**Objection to Planning Application 3/2026/0153**  
**Proposal: Formation of a stone access track and improvements to an existing access**  
**Location: Land off B6478, Slaidburn**

**Objection to Planning Application: 3/2026/0153**  
**Proposal: Formation of a stone access track and improvements to an existing access**  
**Location: Land off B6478, Slaidburn**

Proposed Access Plan
Scale 1:200 @ A3

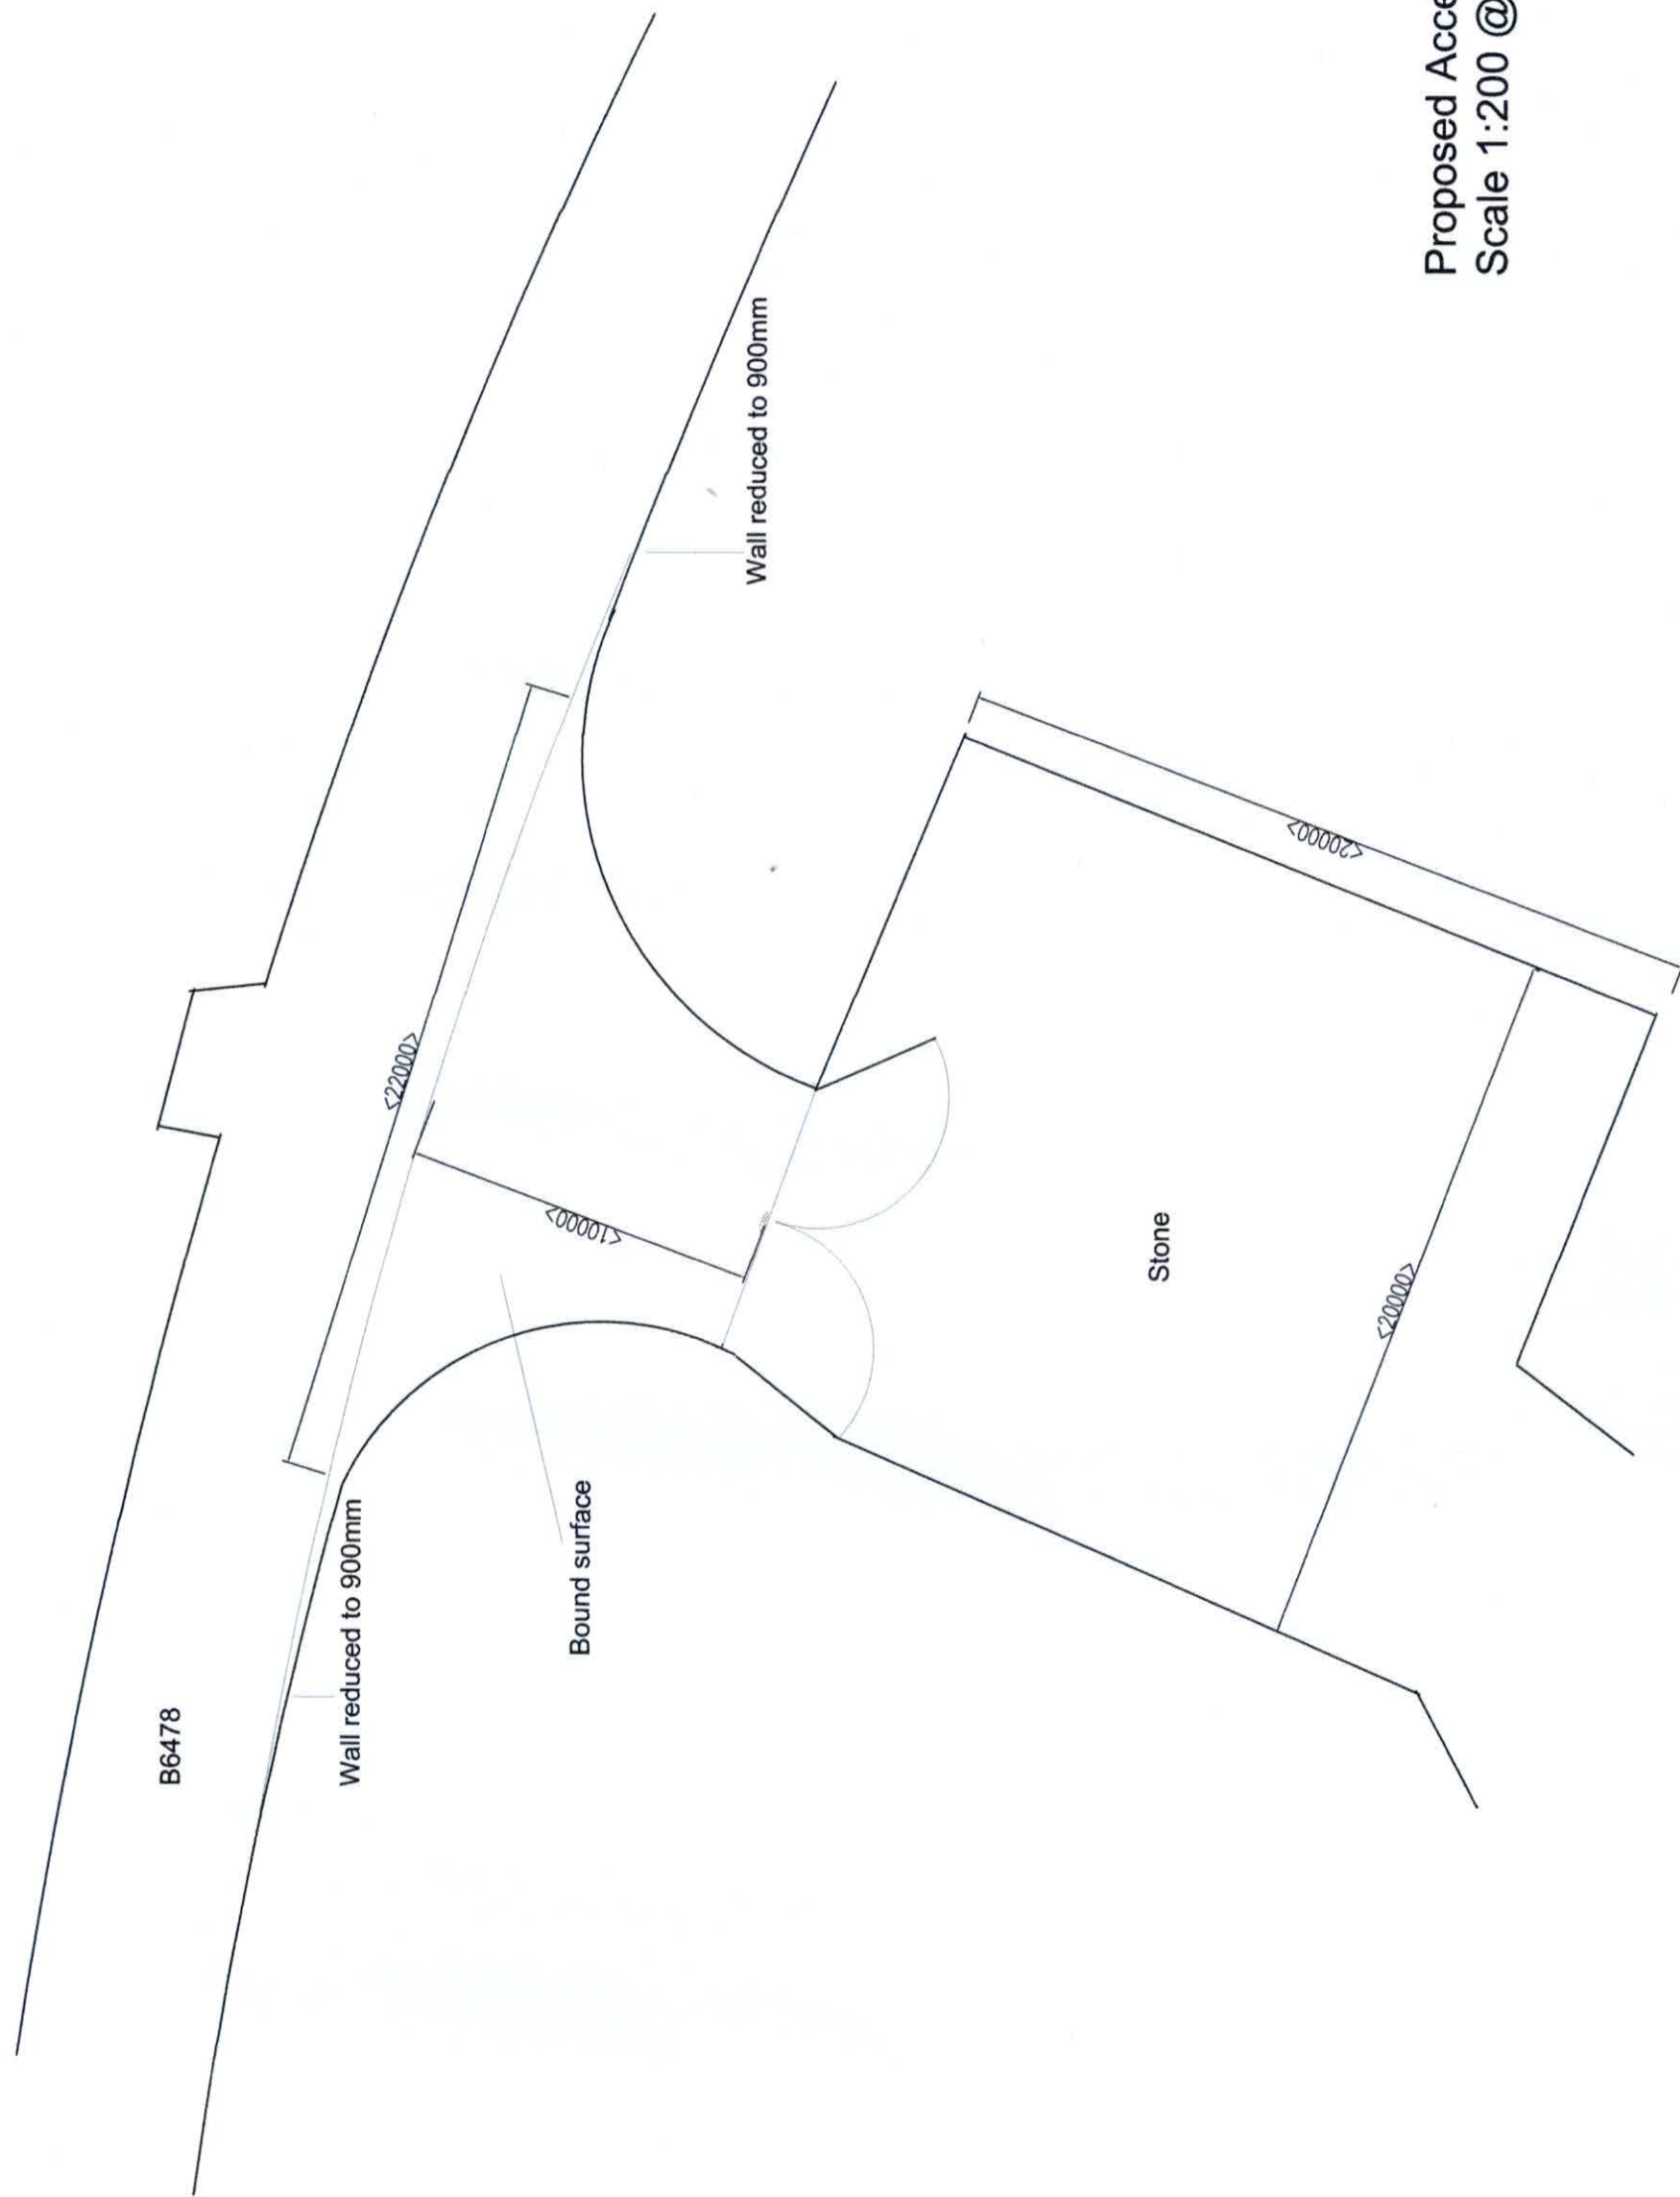
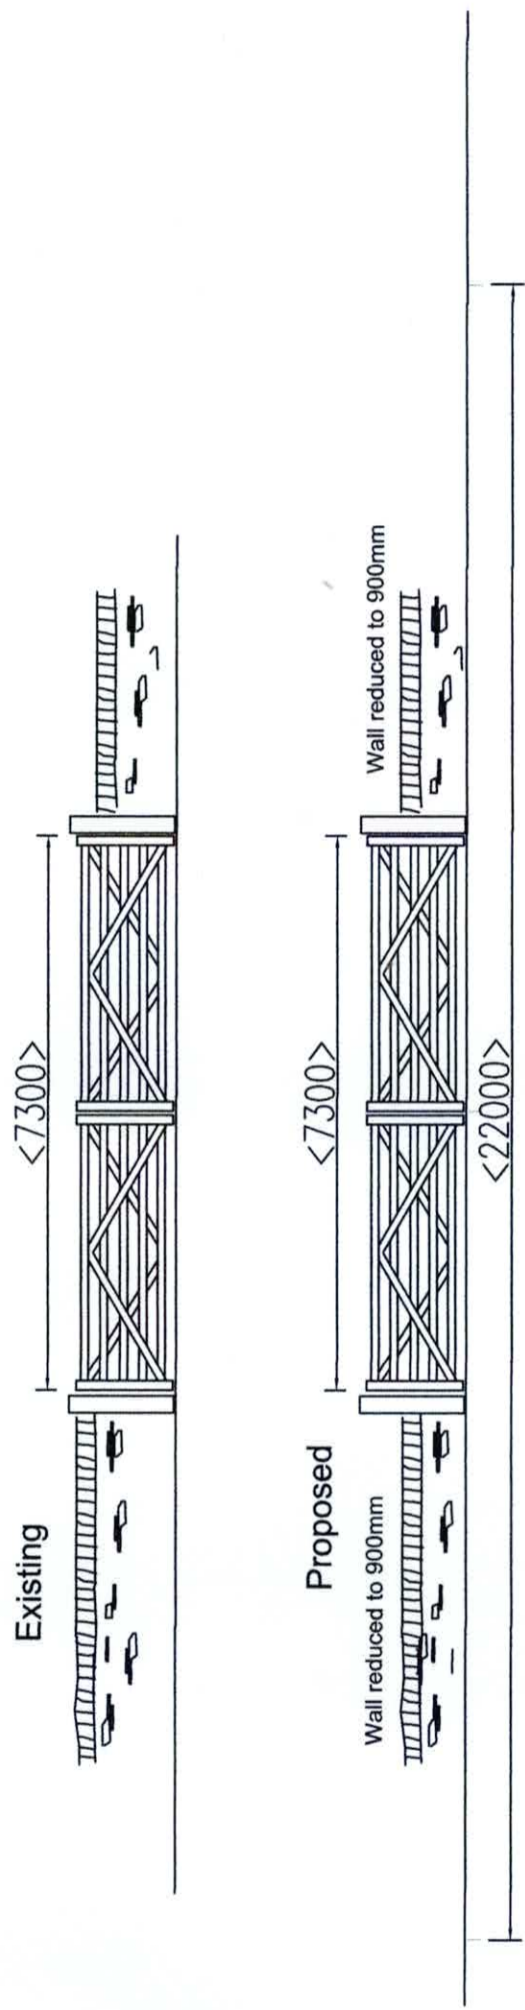
Reduced wall heights rather than full visibility compliance  
Temporary signage and volunteer traffic marshals during events

This implicitly acknowledges that the access is substandard for the scale of traffic anticipated. Moreover, the development facilitates increased vehicle movements rather than addressing a purely existing need. The highway and traffic implications have not been robustly assessed.

Proposed Site Plan  
Scale 1:2000 @ A3

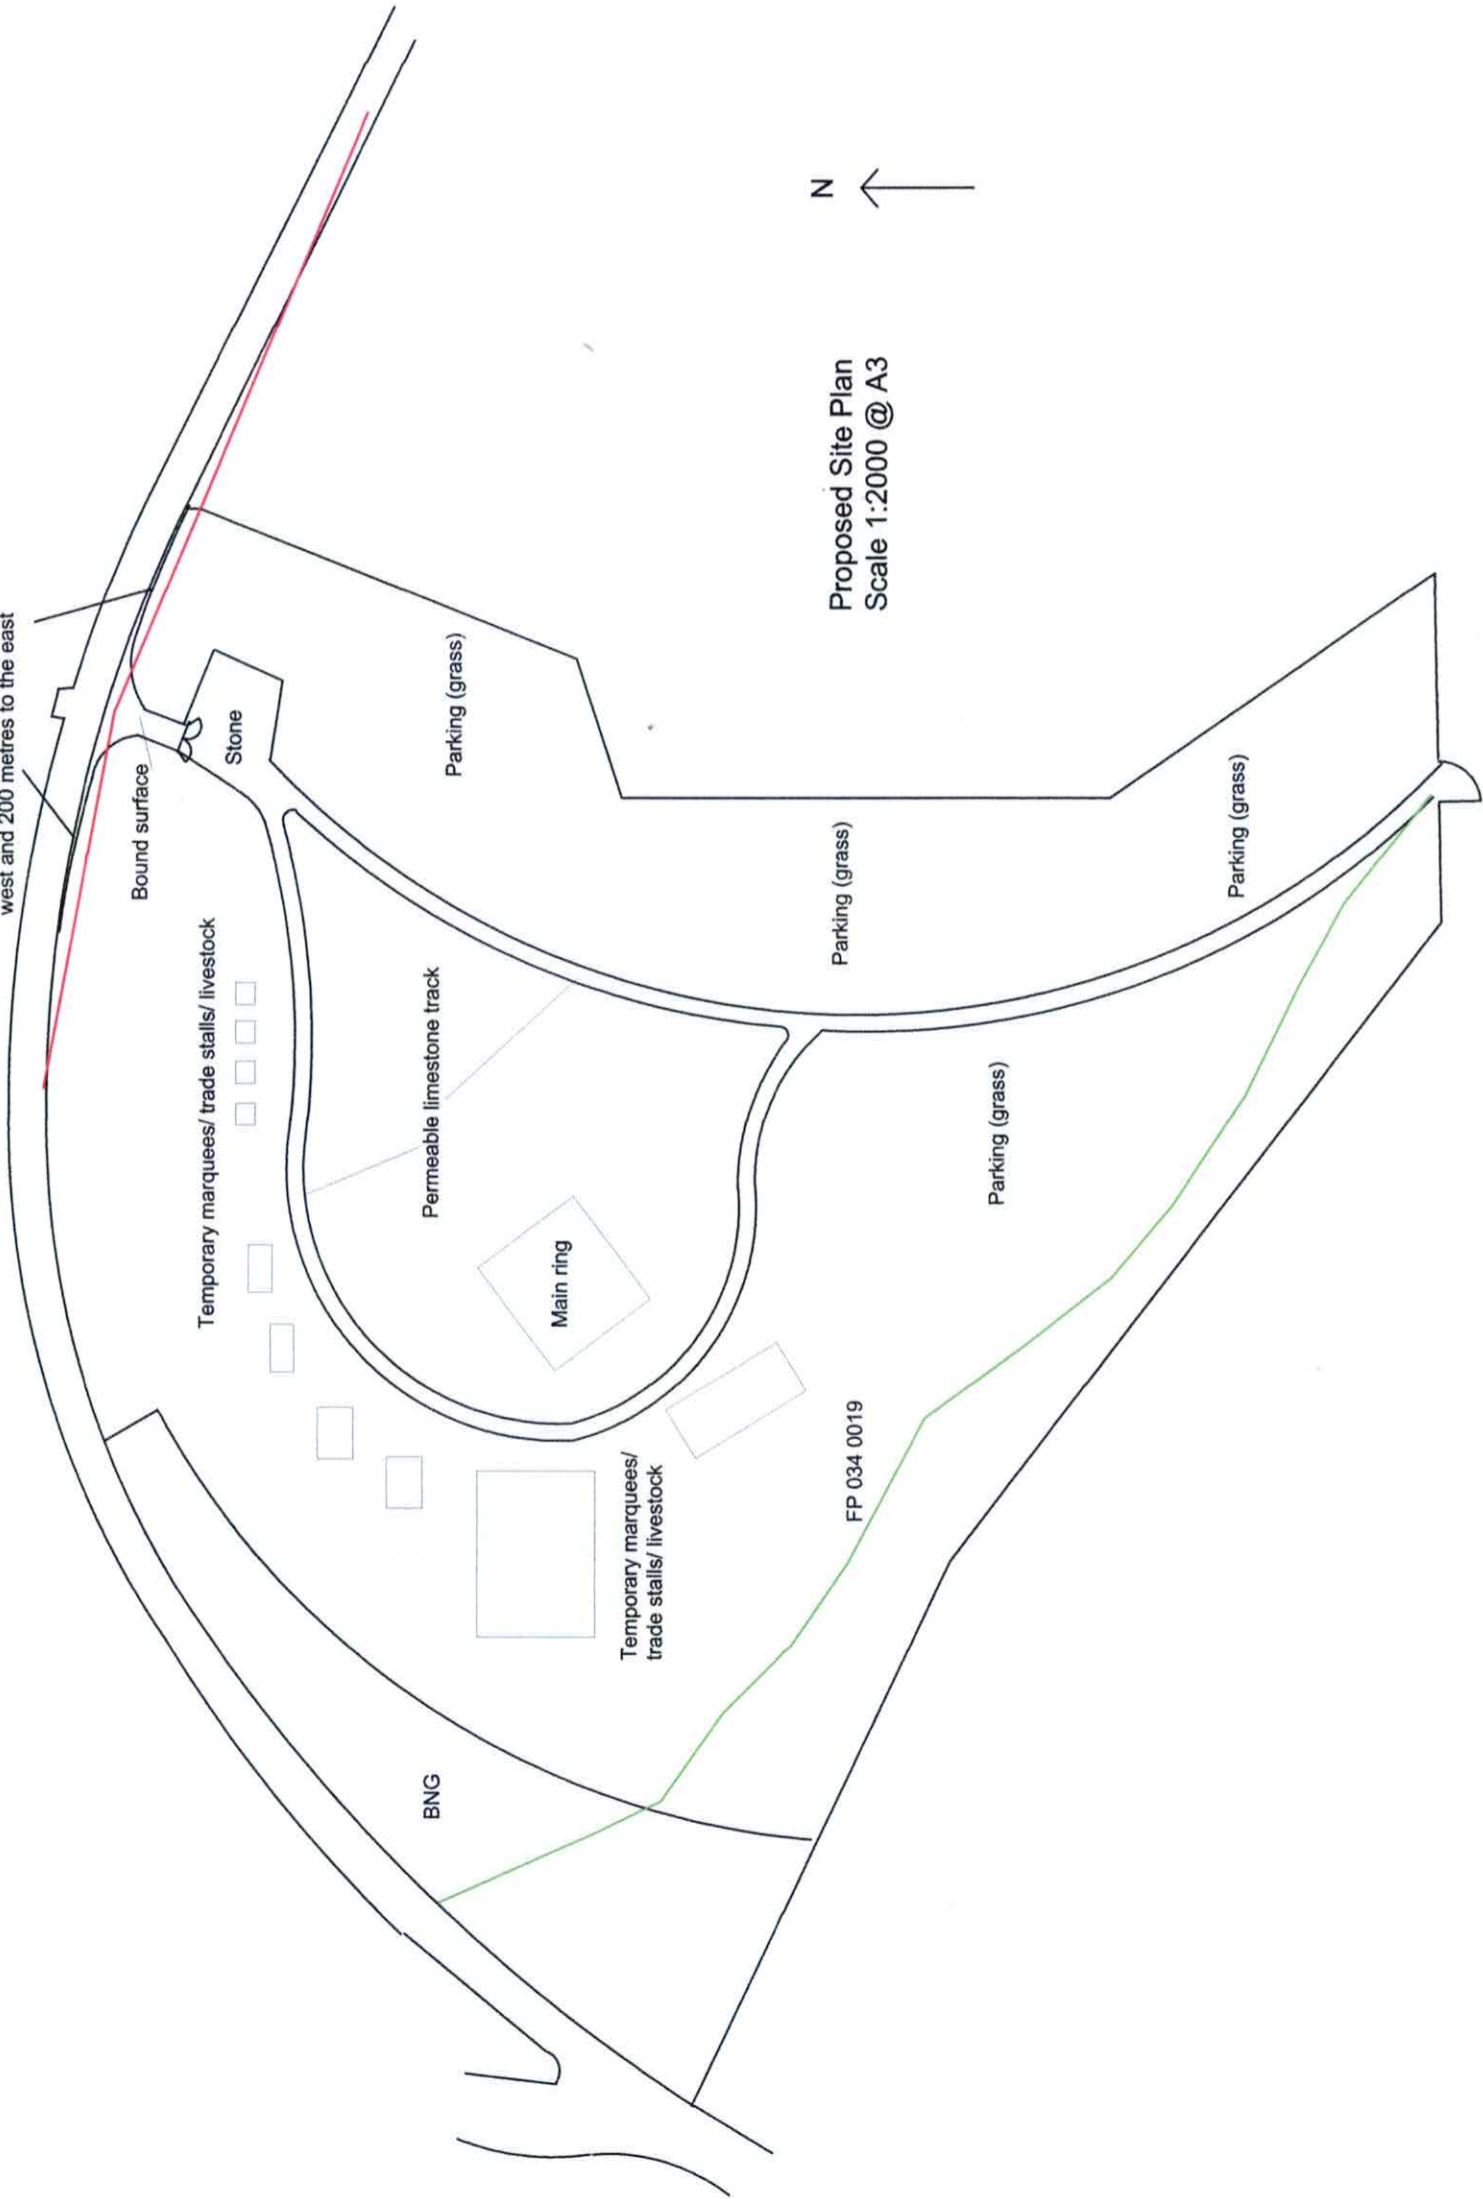
The application description refers only to "Formation of a stone access track and improvements to an existing access". However, the submitted Proposed Site Plan and Design & Access Statement clearly demonstrate that the development is intended to facilitate a permanent agricultural show and event site, including:

- A looped vehicular circulation route
- A central "main ring"
- Areas identified for temporary marquees, trade stalls and livestock
- Grass parking areas
- Infrastructure designed to accommodate large volumes of vehicles and pedestrians

This represents a significant intensification of use, and potentially a material change of use of agricultural land, the impacts of which have not been accurately described or fully assessed within the application.

- Over 4,000m<sup>2</sup> of engineered stone track
- Formalised access splays and bound surfaces
- Urbanising features into open countryside

This is not minor or incidental development. No Landscape and Visual Impact Assessment has been submitted to demonstrate compliance with Core Strategy Policy EN2 or NPPF paragraph 176. The proposal would erode rural character and set an undesirable precedent within a protected landscape.

Public Footpath FP 034 0019 crosses the application site. The proposed site plan shows vehicular routes, event infrastructure and parking areas in close proximity to the PROW, with no physical segregation or mitigation.

Pedestrian safety  
Conflict between vehicles and walkers  
Degradation of the amenity and enjoyment of the PROW
